Tuck O'Brien  
City Planning Director, Planning Division

May 13, 2016

Project Name: **Conversion of Sala Thai to Taco Bell with drive-through**  
Project ID: #2016-007  
Address: 1363 Washington Avenue, Portland CBL: 401 A002001  
Applicant: Guggenheim Retail Real Estate Partners, Inc.  
Planner: Jean Fraser

Not Approved for Construction  
Drawing Title  
**Layout & Materials**  
Drawing Number

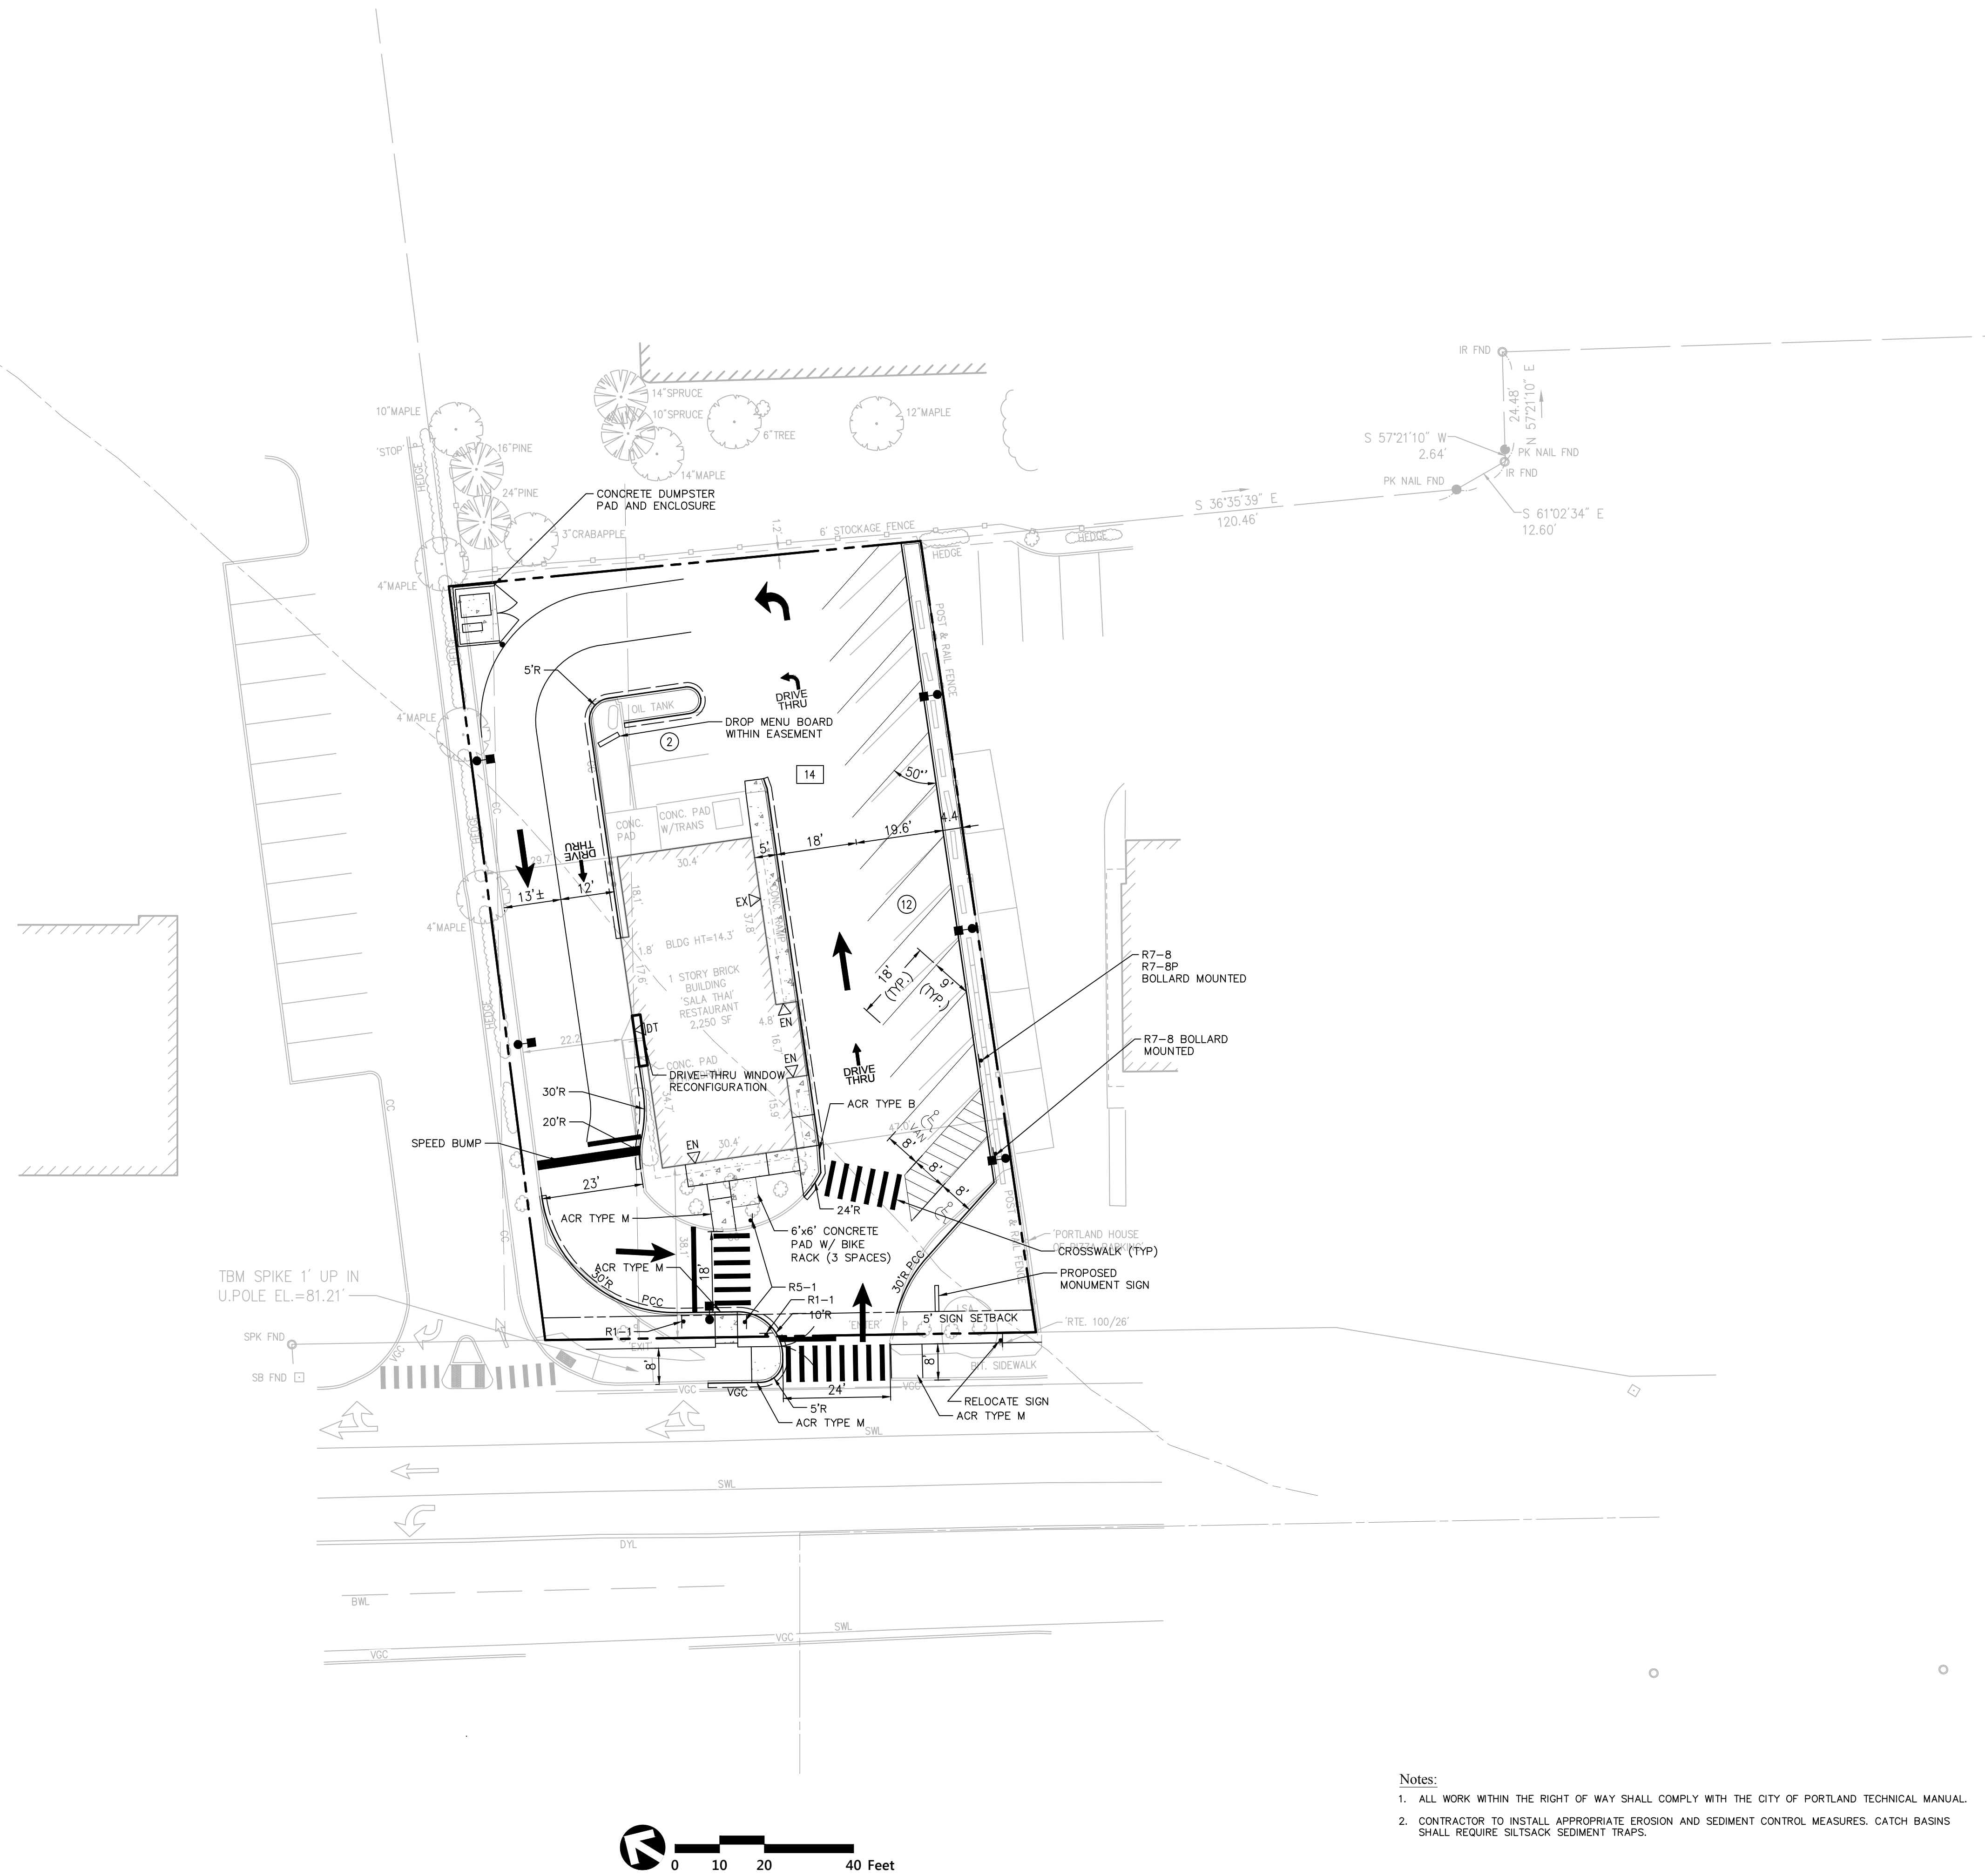
The Planning Authority waives the Technical Standard, Section 1.14 and associated figures, which specify aisle widths and parking space dimensions, to allow the parking lot layout to be based on 50 degree angled parking as shown on the approved Layout Plan.

**Siltsack Sediment Trap**  
 N.T.S. Source: VHB LD\_674

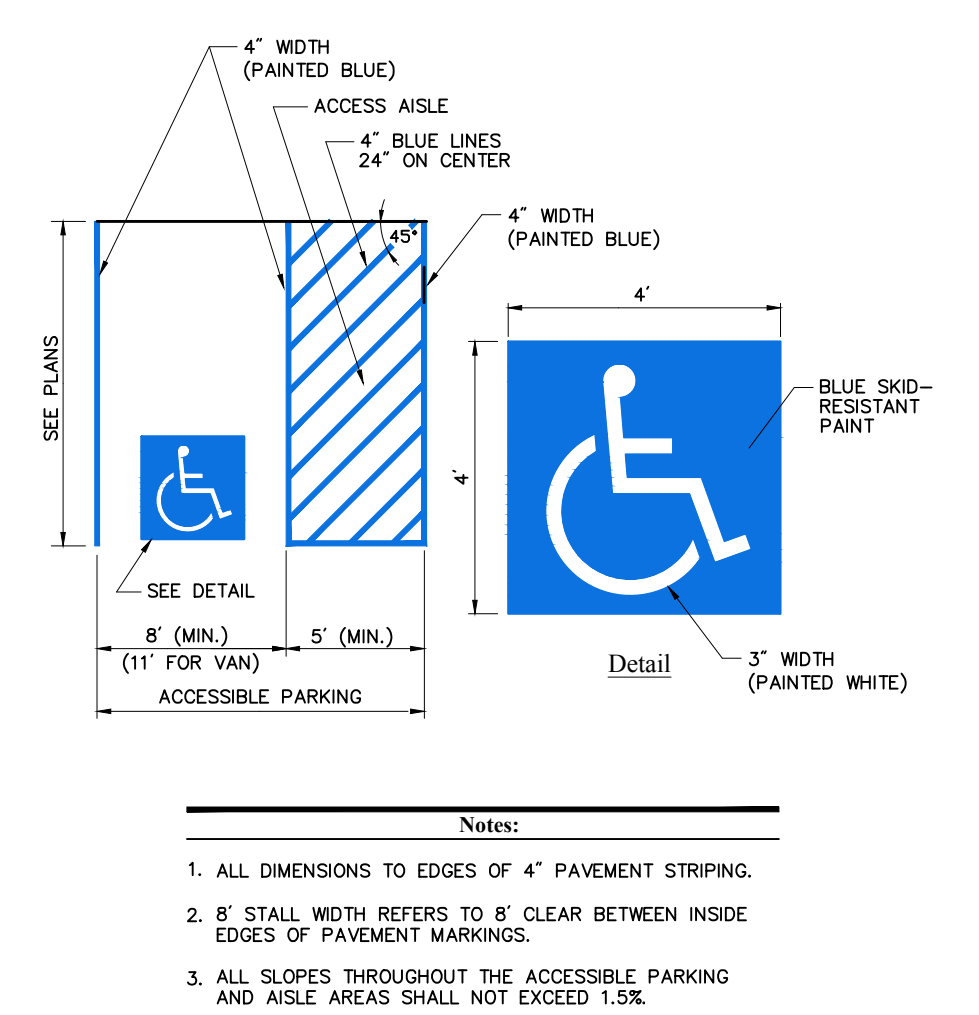
- v. That the plans shall be revised to include additional erosion and sedimentation control notes as listed below, with all these revised plans to be included in the Final Plan set and submitted prior to the issuance of a building permit:

- b. Siltsack sediment traps shall be installed in all existing catch basin structures located within the site and immediately downstream of the construction site.
